ReDirect Recycling Pty Ltd – SSD10474 - 25 Dunheved Cct, St Marys

Response to Agency Comments – 08/09/21

DWG No.		20202CAD006	
		FIGURE 1	
DATE STAMP			
02 SEPTEMBER 2021			
PROJECT No.	SCALE	REV.	
20202	1:300 @A3	A

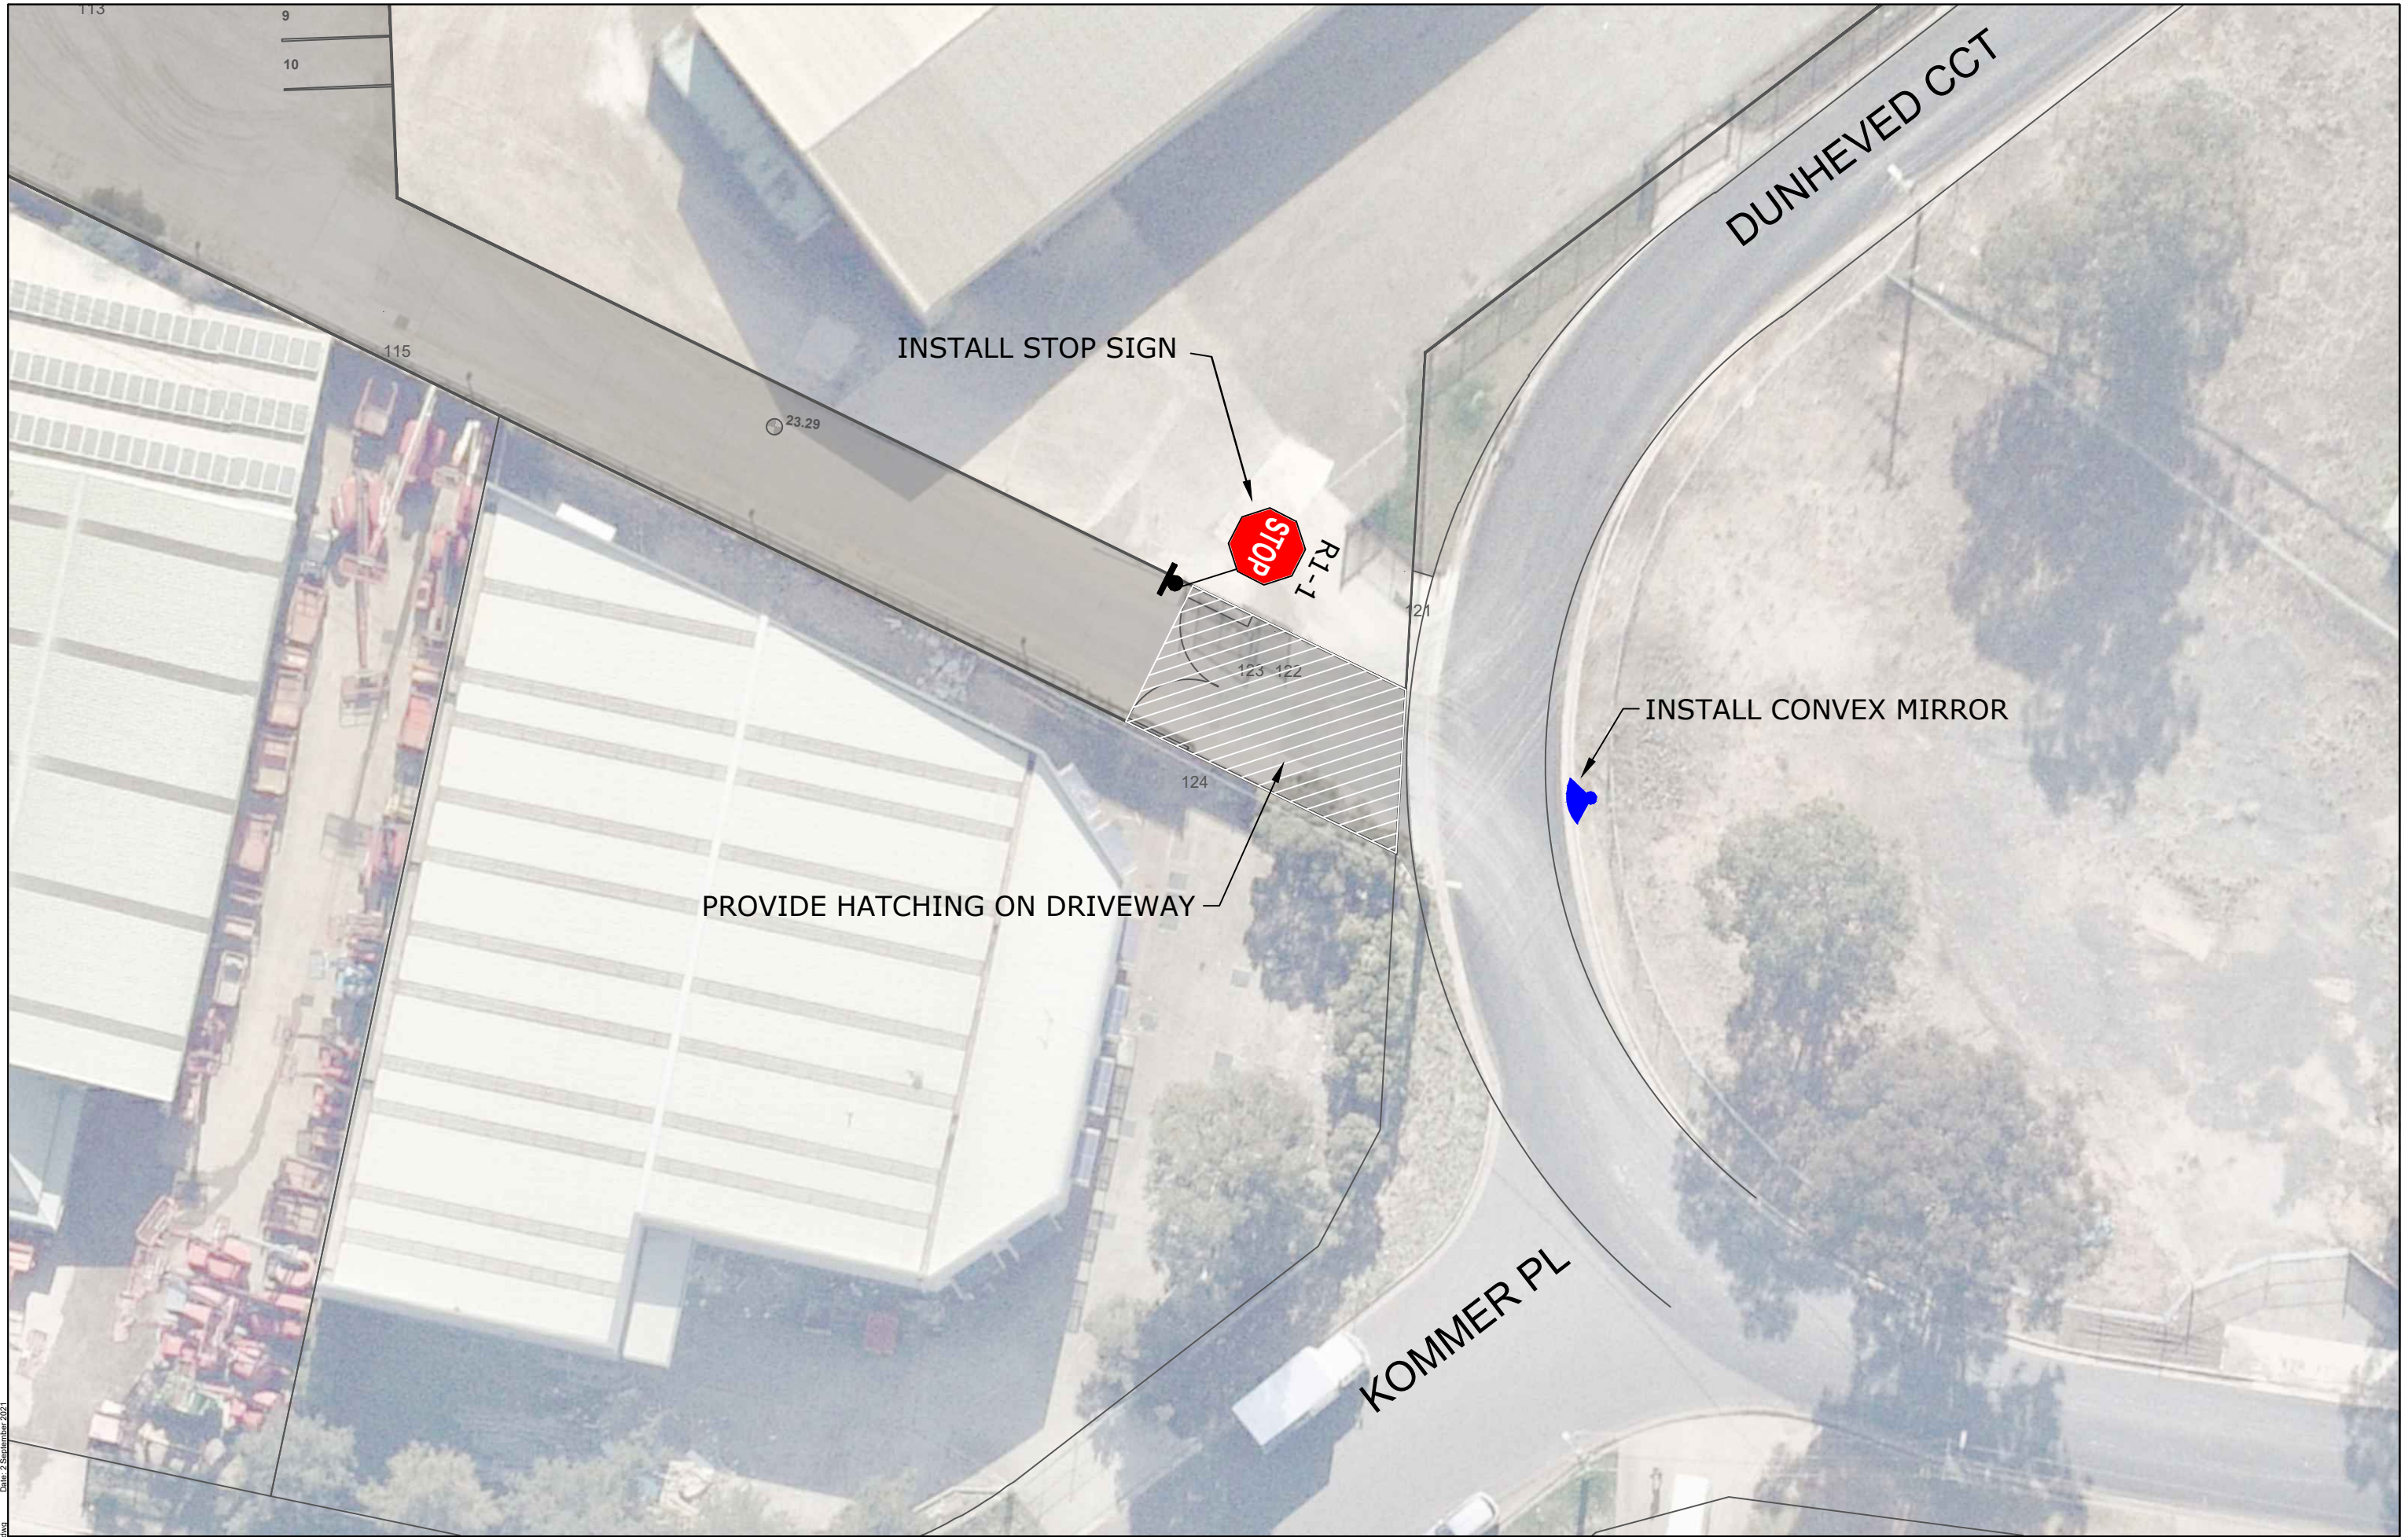
8	Traffic	DPIE	<p>The Department notes that the swept path analysis (Appendix G of the RtS) shows that 19m articulated vehicles require the whole driveway width for the property when entering and exiting the site, and therefore only one vehicle could enter or exit the site at one time.</p> <p>Please provide further details on how the movement of vehicles in/out of the site will be managed to ensure safe and efficient access to the site.</p>	<p>Our traffic engineer, TTPP has evaluated vehicle safety for exiting and entering trucks into and out of the site. The probability of conflict has been assessed. The analysis is given in Attachment 2. The results should that the probability of a vehicle entering and exiting the site is the conflict area at the same time is very low (0.05% or a 1 in 2020 chance).</p> <p>Although the risk of conflict at the entry/ exit point to and from the site is low, TTPP have recommended some additional</p>

No.	Topic	Agency / submission	Comment	Response
				<p>mitigation measures to manage and reduce potential impacts. This includes:</p> <ul style="list-style-type: none"> • Providing hatched marking on the driveway to identify the area of potential conflict so drivers can be reminded to exercise caution on leaving and entering the site; • Install a stop sign for vehicles prior to exit from the site; • Install a convex mirror on a post on the opposite side of Dunheved Cct to enhance driver visibility; • Site induction and staff training for truck drivers and operational staff. Truck drivers will also be required to radio on approach to the site to inform tip floor staff of the truck's arrival, providing advance warning to the vehicle's arrival to the site. <p>TTPP conclude these measures will help manage and reduce the potential for conflict at the entry/exit to the site.</p>
9	Traffic	DPIE	While it is acknowledged that the adjoining property at 21 Dunheved Circuit is under the same ownership and 'currently vacant', further consideration is required with regard to any necessary measures to ensure the safe operation of heavy vehicles concurrently on both properties, particularly trucks accessing the rear of 21 Dunheved Circuit.	Each property has its own access, with each having space for two heavy vehicles to pass each other. The swept path analysis provided as Appendix G in the RTS report shows that there is sufficient space for large vehicles to manoeuvre on 25 Dunheved Cct without the need to drive onto the neighbouring property. If 21 Dunheved Cct is developed, the traffic needs for that site will be assessed within the development application for that site.
